From: Meg Lippert <meg.lippert@gmail.com>
Sent: Monday, August 22, 2016 4:47 PM
To: Scott Greenberg; Kari Sand; Ali Spietz
Subject: SEPA16-015 and ZTR16-002
Attachments: Sepa Letter.pdf

Please accept this email along with the attached comment letter from the Concerned Citizens for Mercer Island Parks (CCMIP) as my comments to MICA's SEPA checklist and proposed zoning code amendment. I agree, incorporate, and support the comments that are detailed in the attached CCMIP comment letter.

MERCER ISLAND CENTER FOR THE ARTS CONCEPTUAL MITIGATION PLAN

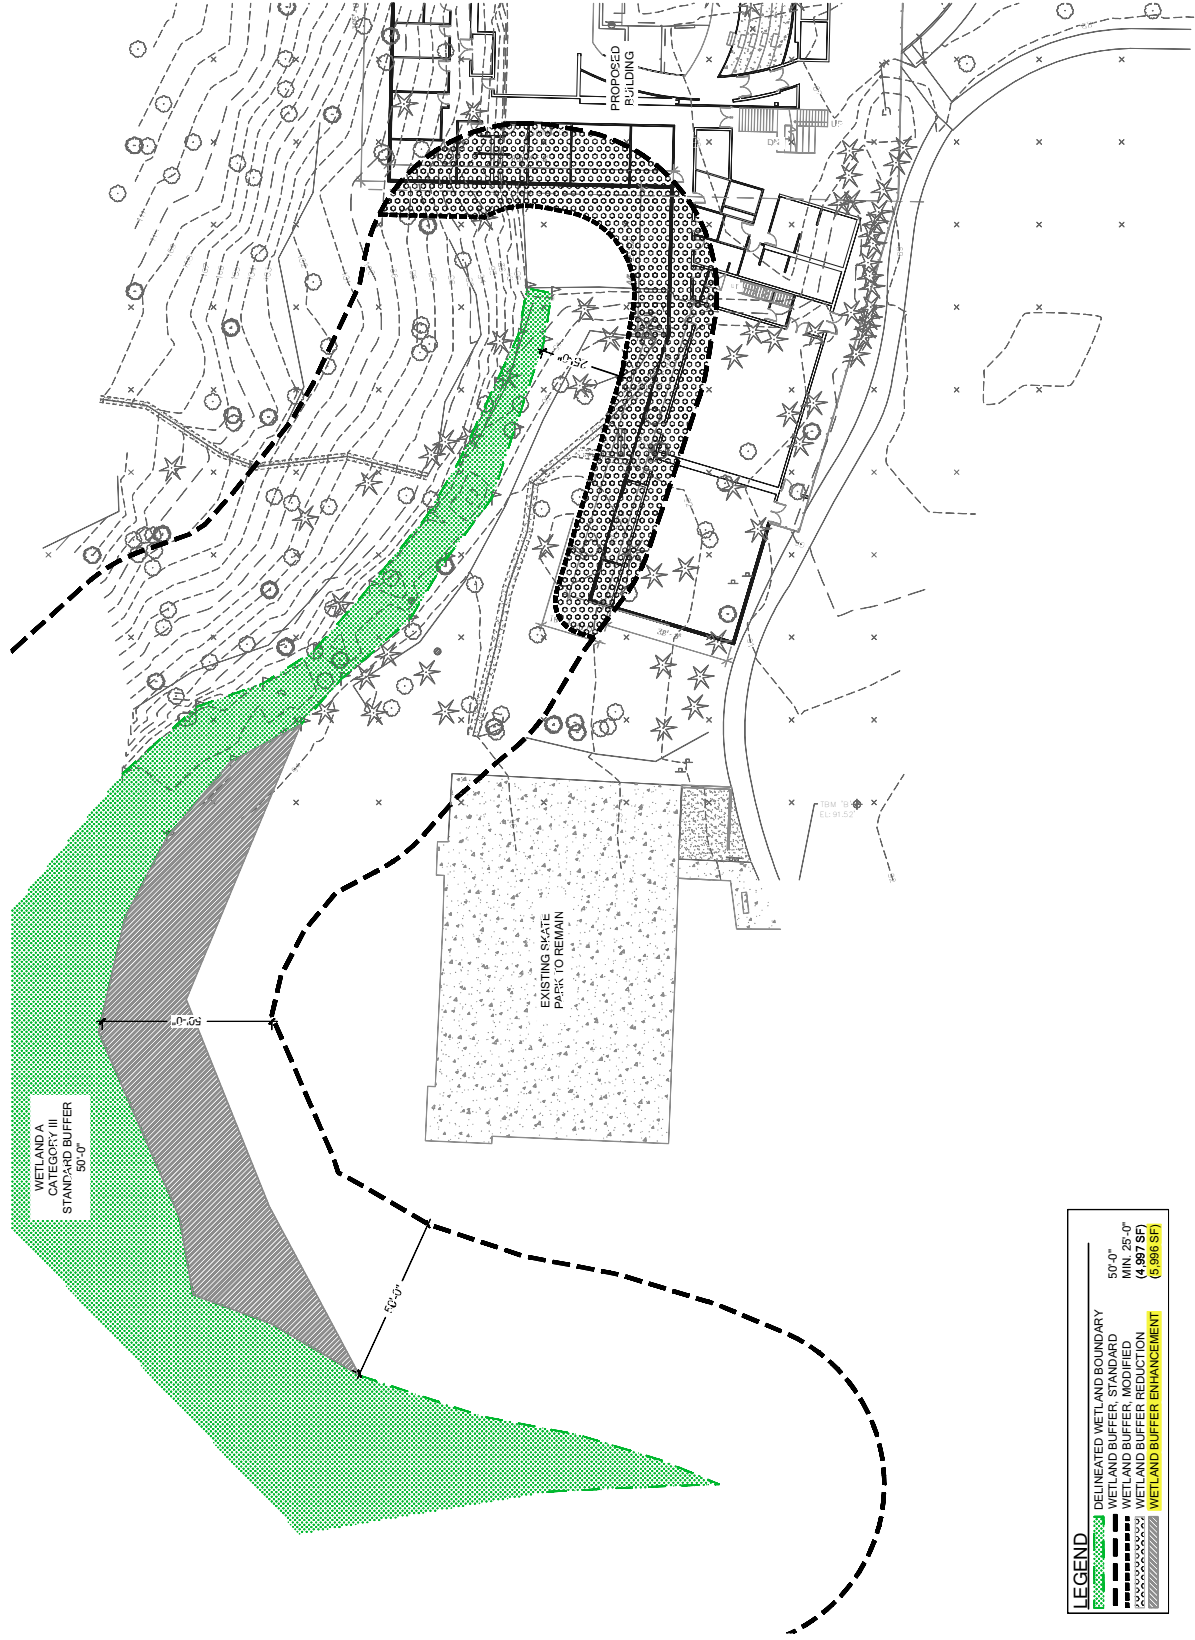
B. 3.a.2. refers to a 25 foot buffer. When and by what authority was the buffer changed from 50 feet to 25 feet? "Wetland mitigation" is mentioned, but no mitigation is described. What is the mitigation, and who will be responsible for approving and supervising it?

SHEET NUMBER
C301

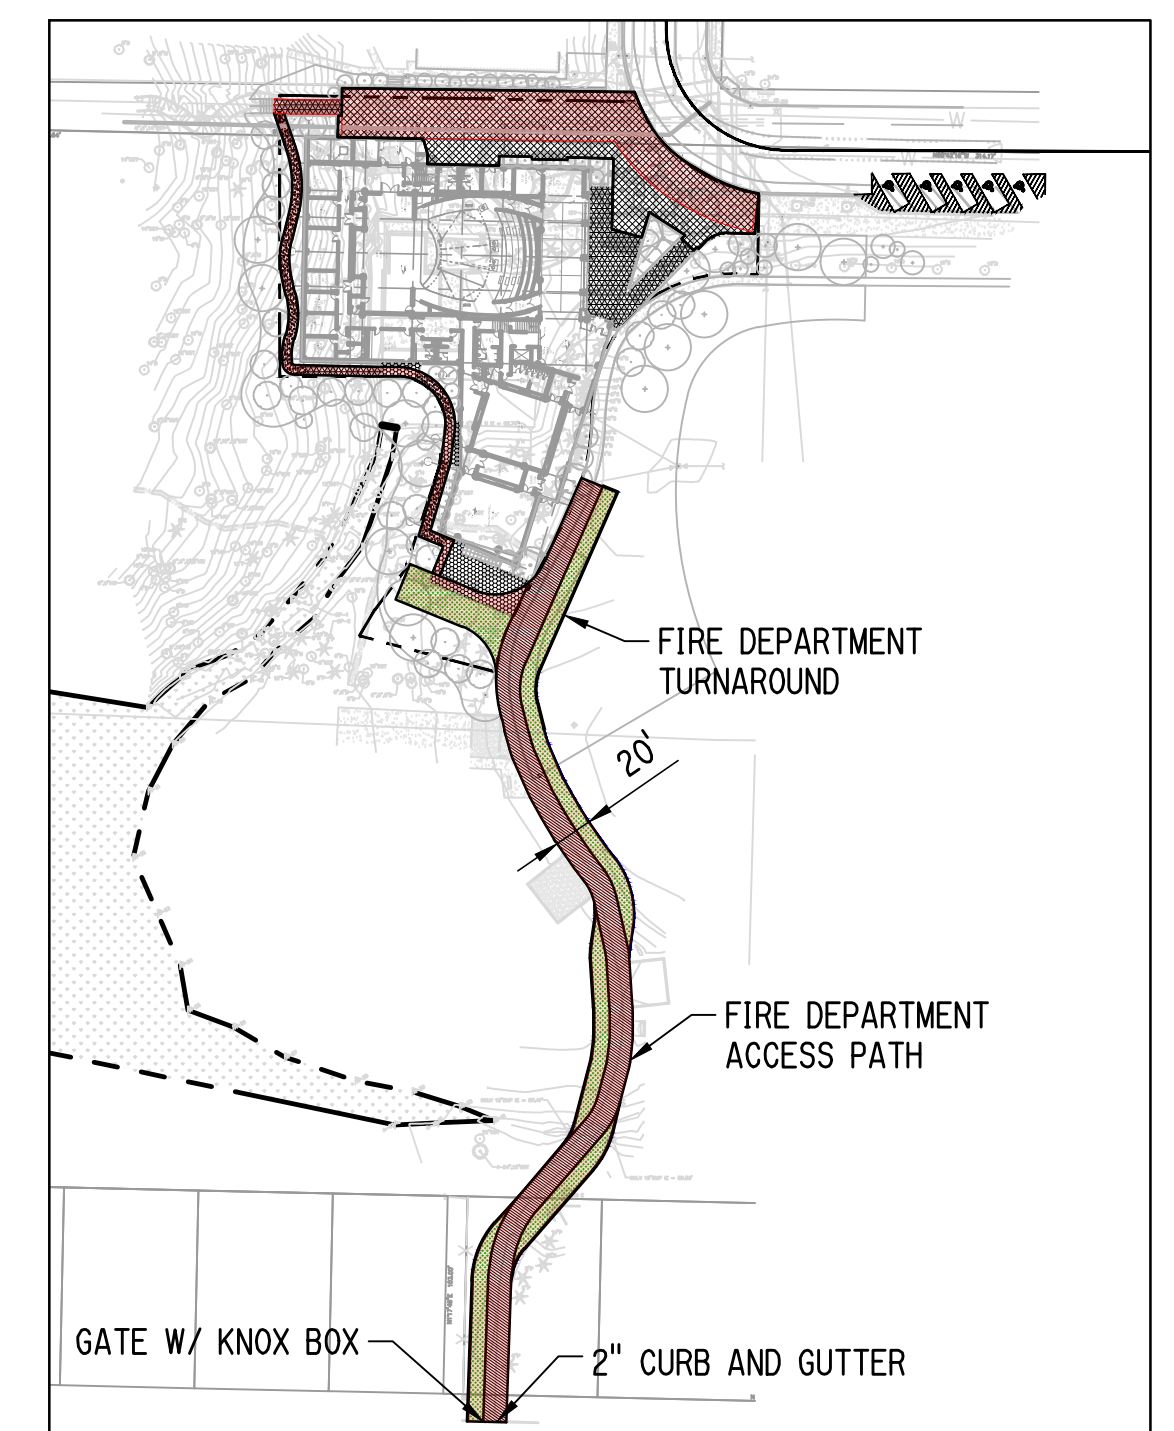
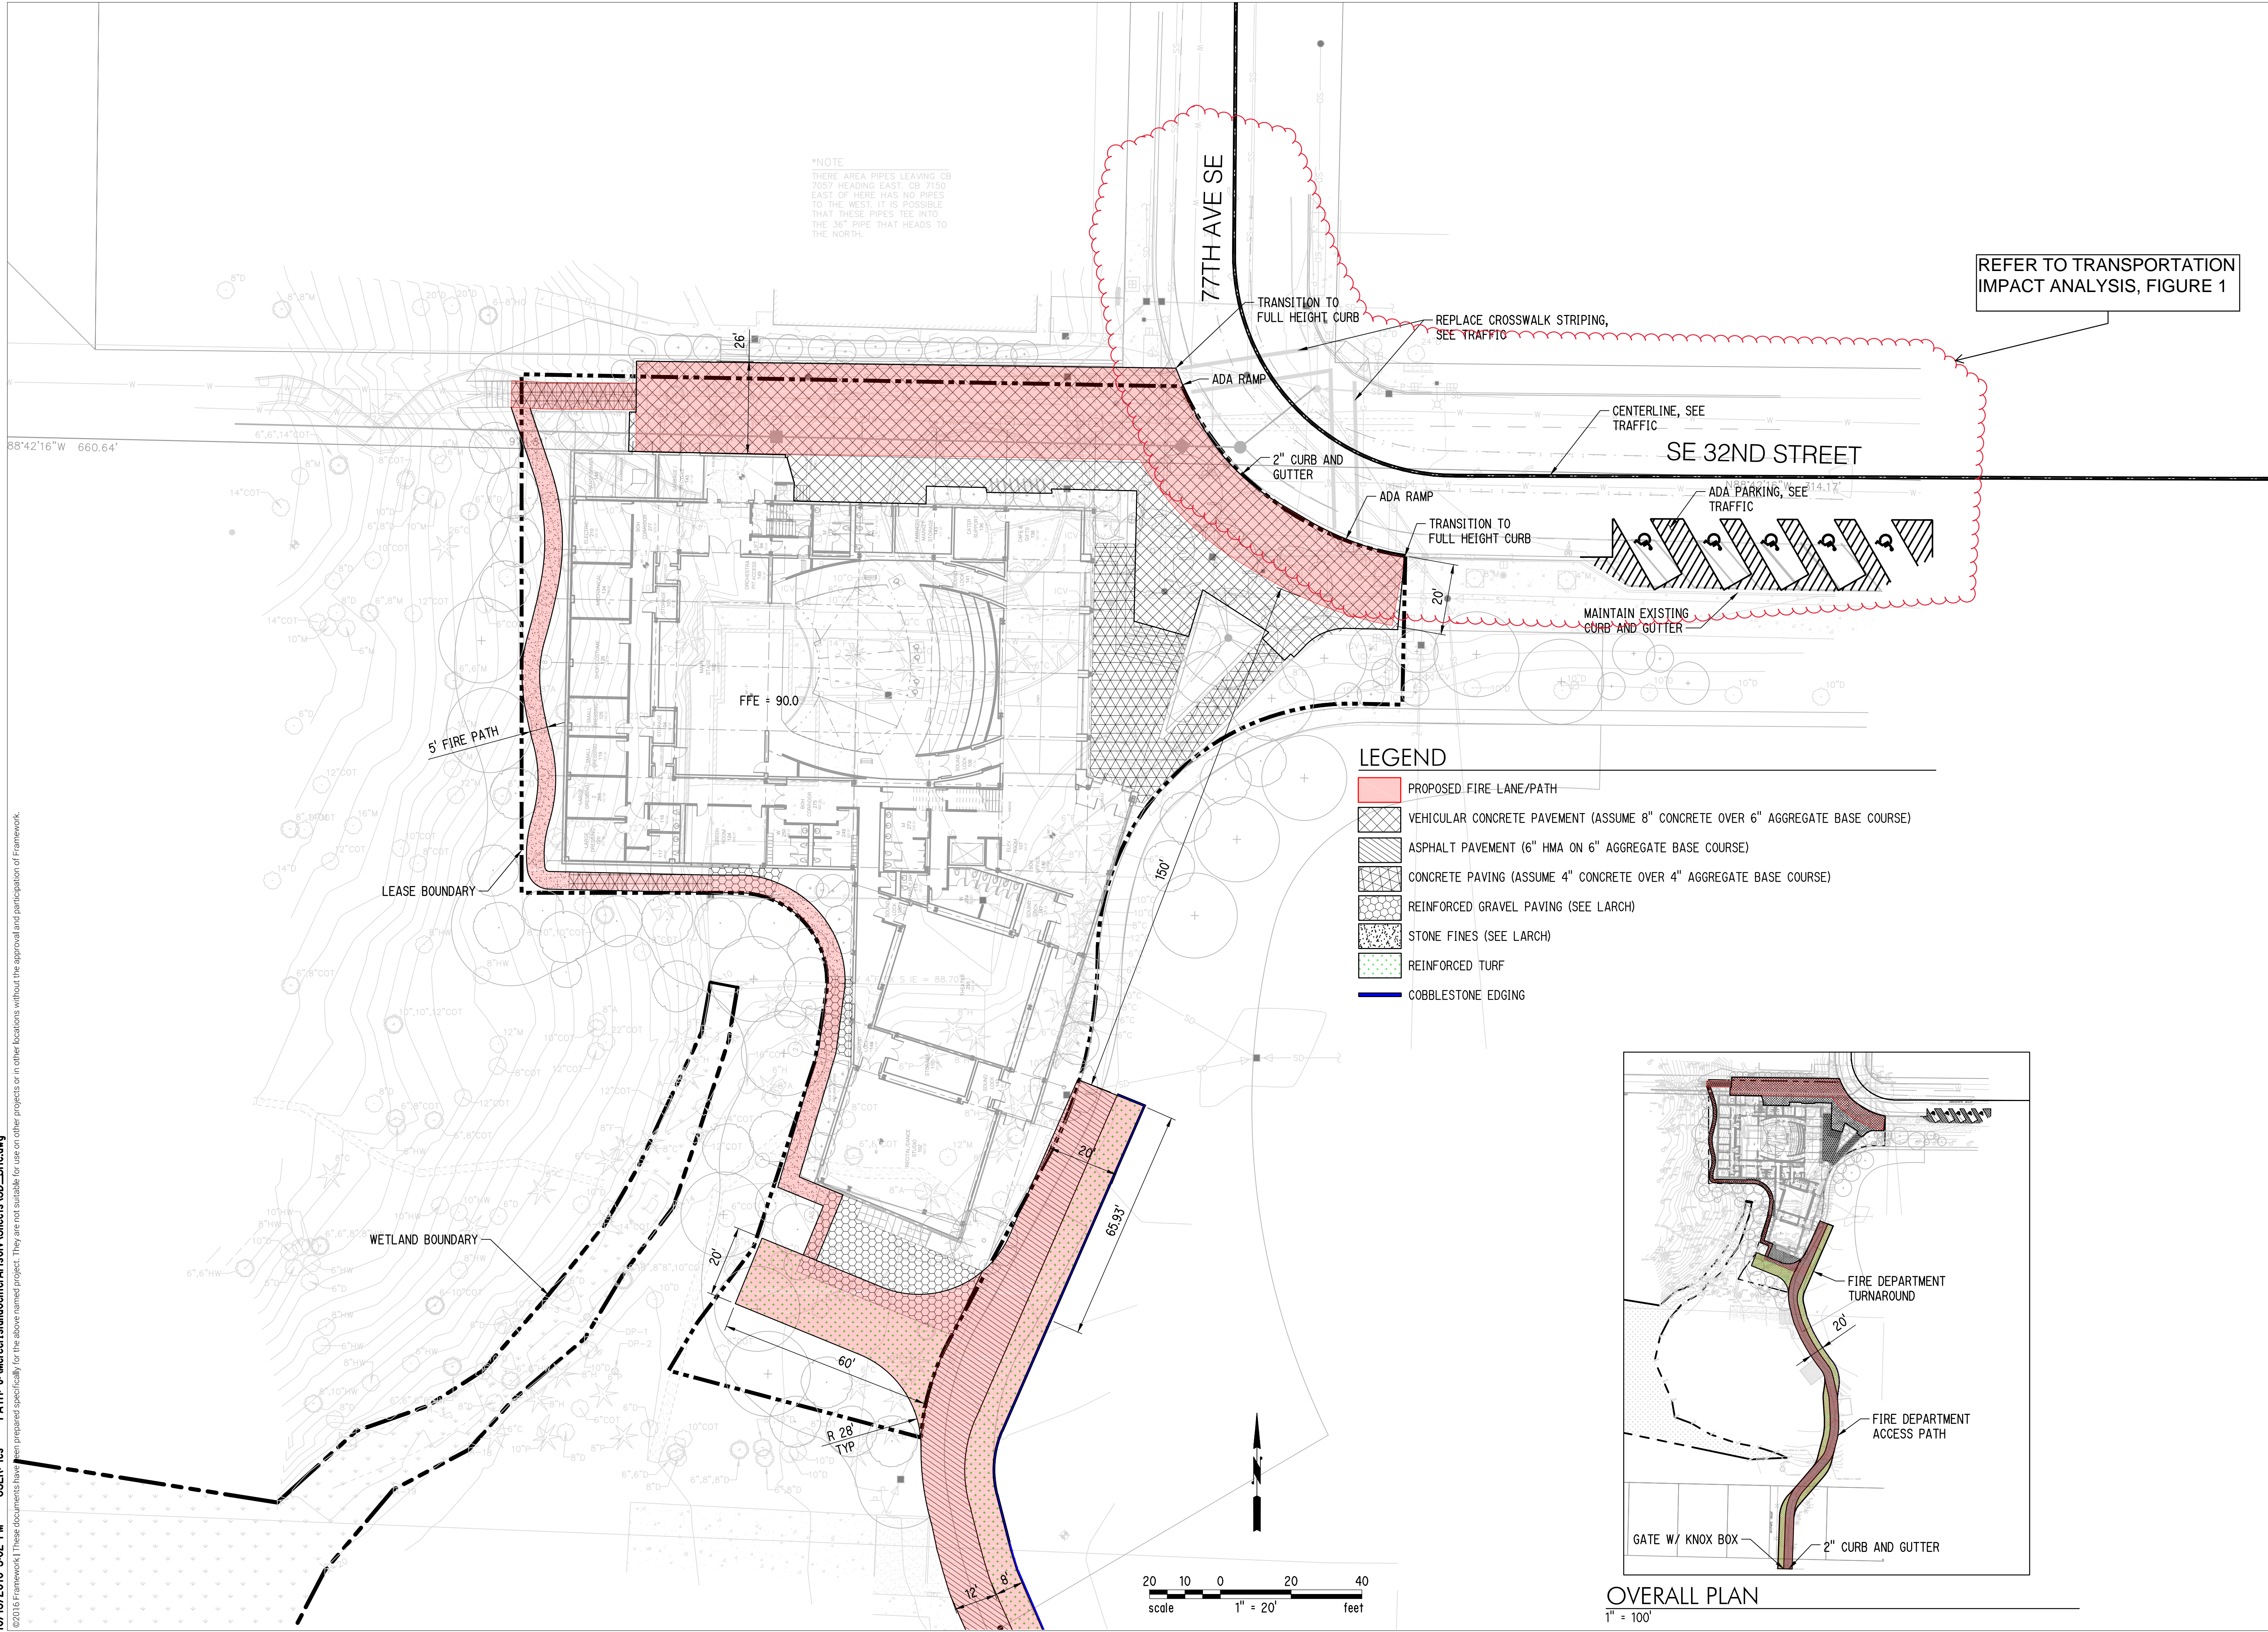
B. 3.c.1. water runoff-where is the bio-retention area and how will runoff water be treated?

B.4.a Plants--"grass" and "other types of plants" should have been checked. Some grass will be covered by pavement according to the site plans, and "other types of vegetation" include pink and white cyclamen and other woodland plants. (I have photographs of these plants blooming in the area which is proposed to be covered, and I would be happy to share these photographs with the City.)
